**Subject:** Rezoning Petition Review

**Rezoning Petition #:** 21-209

**Location of Property:** Approximately 1.66 acres located at the southeast intersection of Steele Creek Rd and Rigsby Rd, north of Dixie River Rd.

RZ1.0

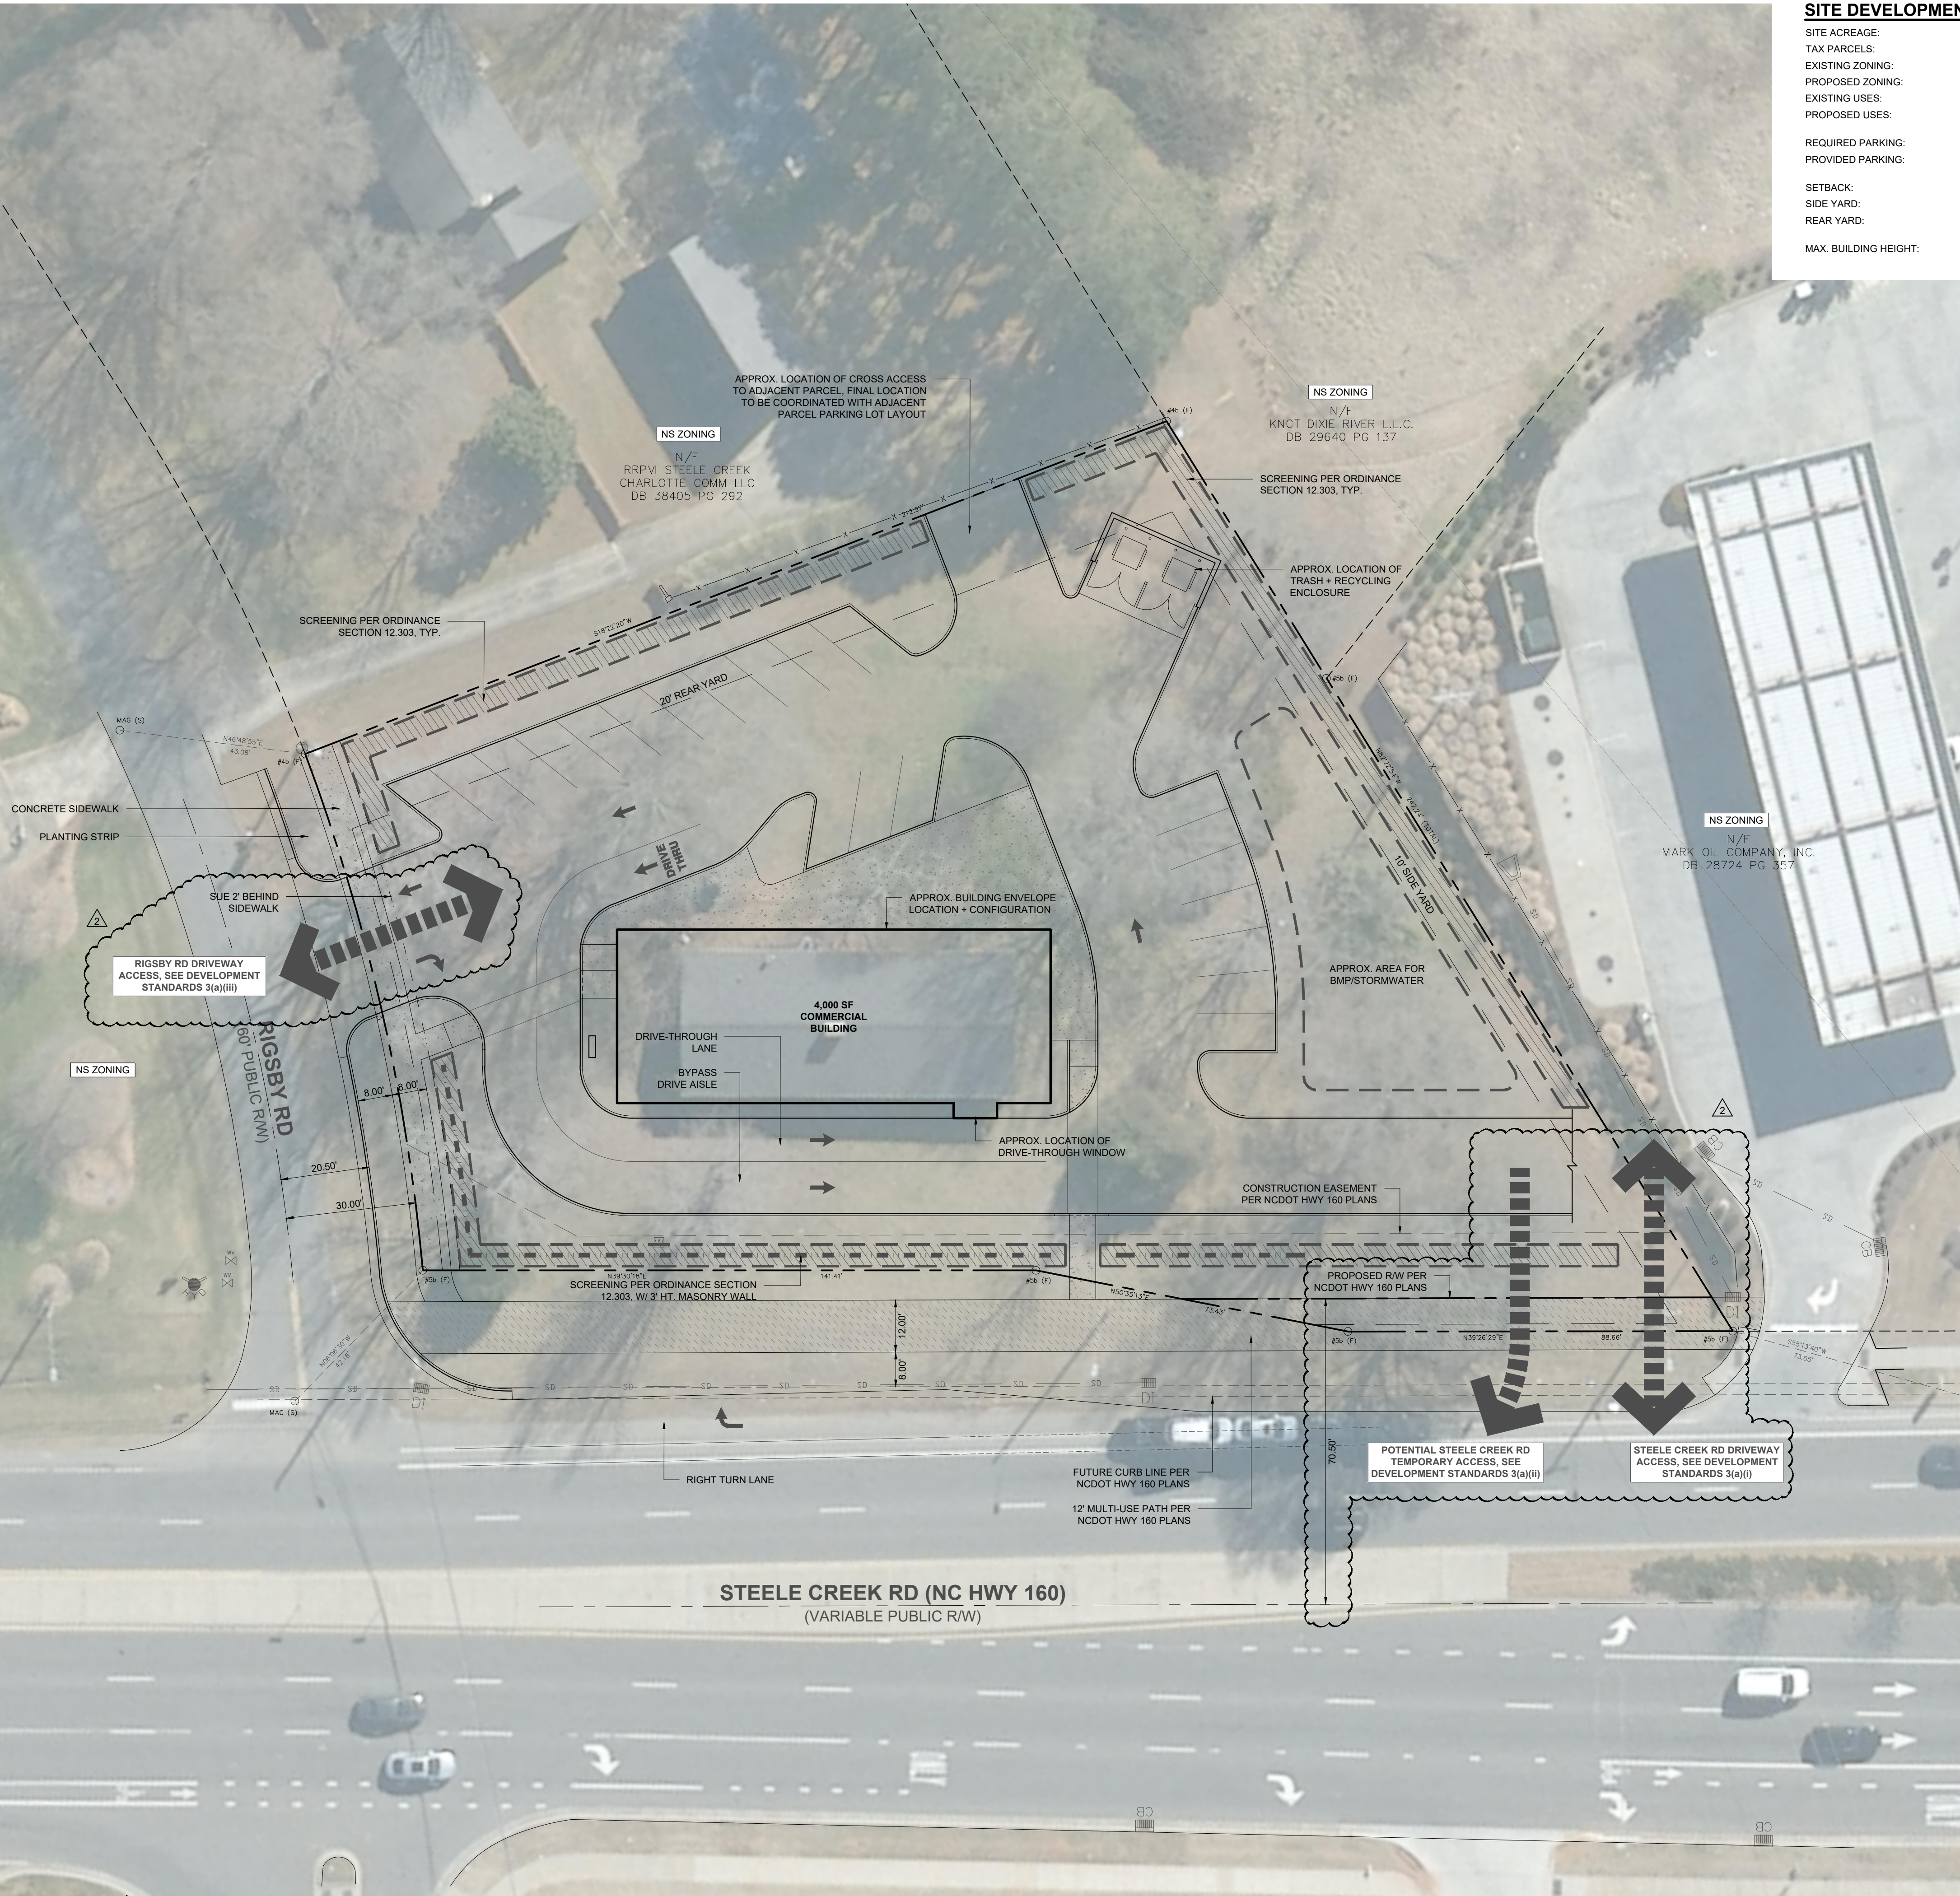
The proposed rezoning plan sheet indicates a proposed location for storm water management. Please include the following notes on the plan sheet under "Environmental Features": The location, size, and type of storm water management systems depicted on the Rezoning Plan are subject to review and approval as part of the full development plan submittal and are not implicitly approved with this rezoning. Adjustments may be necessary in order to accommodate actual storm water treatment requirements and natural site discharge points.

**This property drains to Beaverdam Creek, which is an impaired/degraded stream, and may contribute to downstream flooding. This project has the opportunity to mitigate future impacts to this stream, therefore, Storm Water recommends placing the following notes on the plan:**

(I) Storm Water Quality Treatment

For defined watersheds greater than 12% built-upon area (BUA), construct water quality stormwater control measures (SCMs) designed for the runoff generated from the first 1-inch of rainfall for all new and redeveloped BUA associated with the project. SCMs must be designed and constructed in accordance with the Charlotte-Mecklenburg BMP Design Manual.

(II) Volume and Peak Control

For defined watersheds greater than 12% built-upon area, control the entire volume for the 1-year, 24-hour storm for all new and redeveloped BUA associated with the project. Runoff volume drawdown time shall be in accordance with the Charlotte-Mecklenburg BMP Design Manual.

For commercial projects with greater than 12% BUA, control the peak to not exceed the predevelopment runoff rates for the 10-yr, 6-hr storm and perform a downstream flood analysis to determine whether additional peak control is needed and if so, for what level of storm frequency, or if a downstream analysis is not performed, control the peak for the 10-yr and 25-yr, 6-hour storms.

For residential projects with greater than 12% BUA, control the peak to not exceed the predevelopment runoff rates for the 10-year and 25-year, 6-hour storms or perform a downstream analysis to determine whether peak control is needed, and if so, for what level of storm frequency.
